Re: 1 Joy Place

Jean Fraser <jf@portlandmaine.gov>

Mon, Nov 6, 2017 at 3:59 PM

RECORDING PLAN

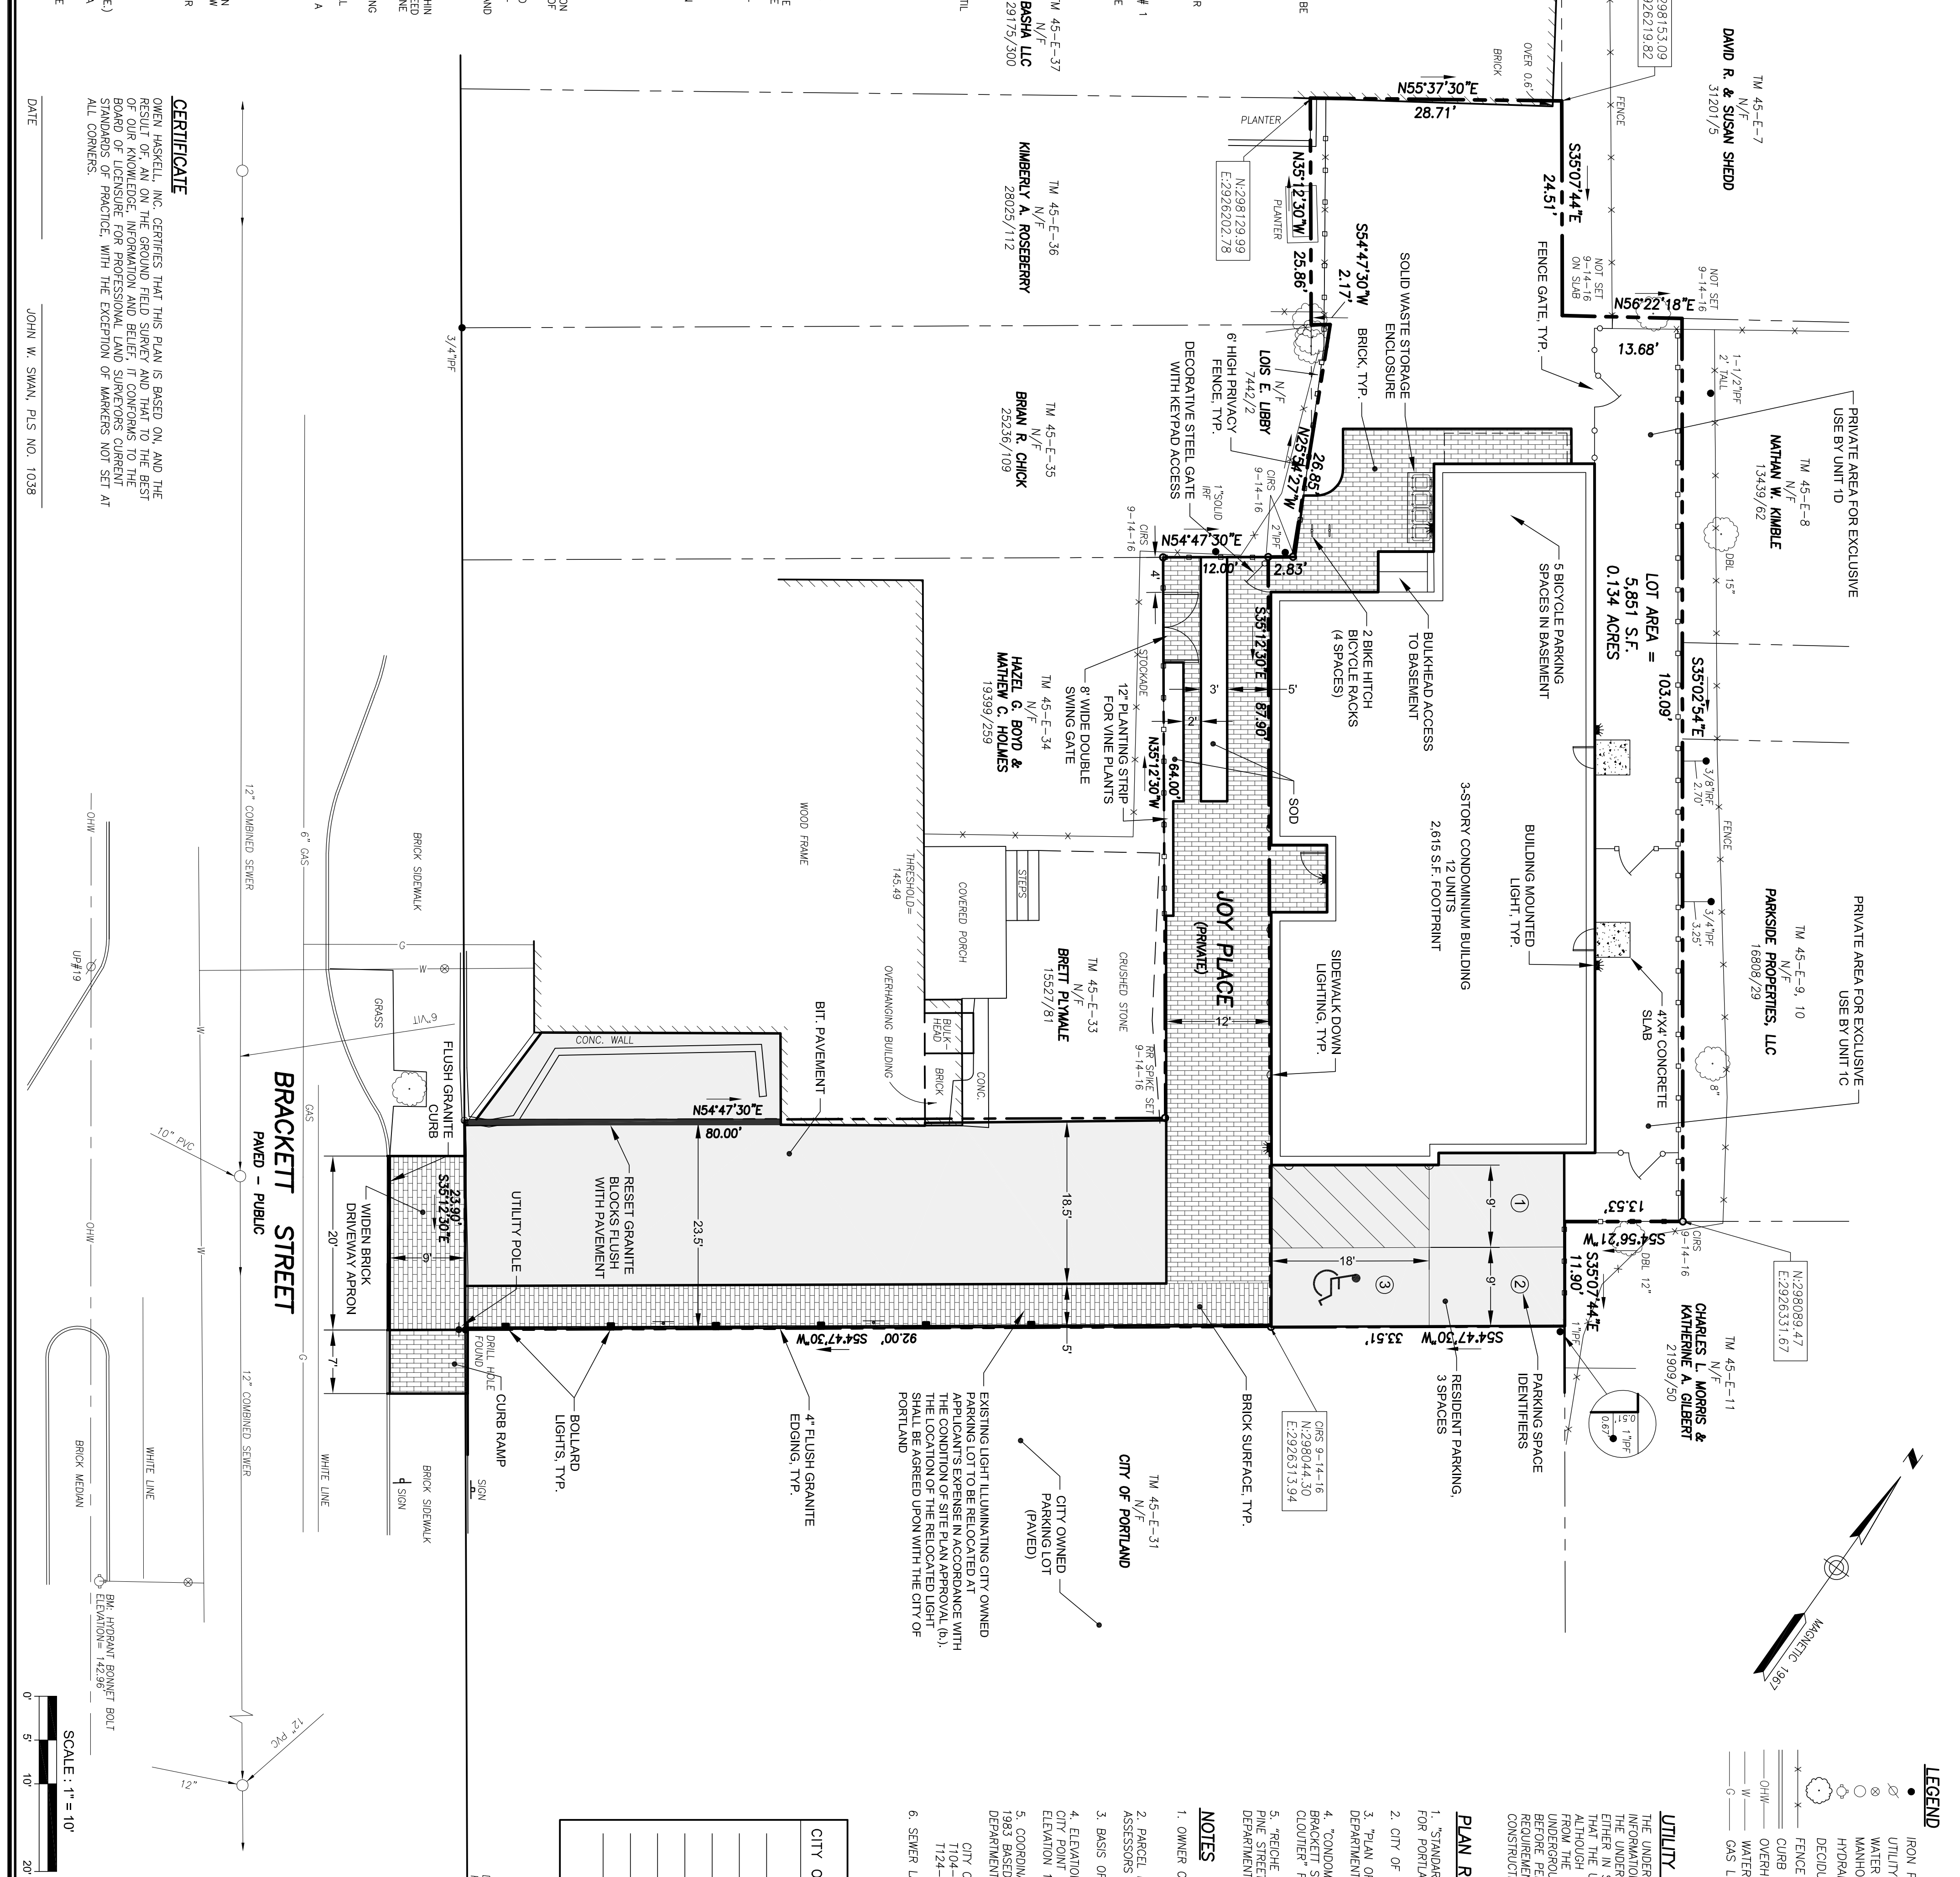
Please send me the draft condominium documents and I will arrange for their review by the Corporation Counsel. However, the condo docs and the Plat should mirror each other in terms of notes and references, so it would be helpful to have the final subdivision plat to review at the same time.

Both should reflect a final decision about the lights* and replacement of the parking lot one, and confirm maintenance arrangements for Joy Place (along with the other points mentioned in the conditions of approval). The site plan approval does not convey any approval to removing these lights and separate legal agreements (documentation of agreement and replacement re the parking lot one) would be needed before they are removed.
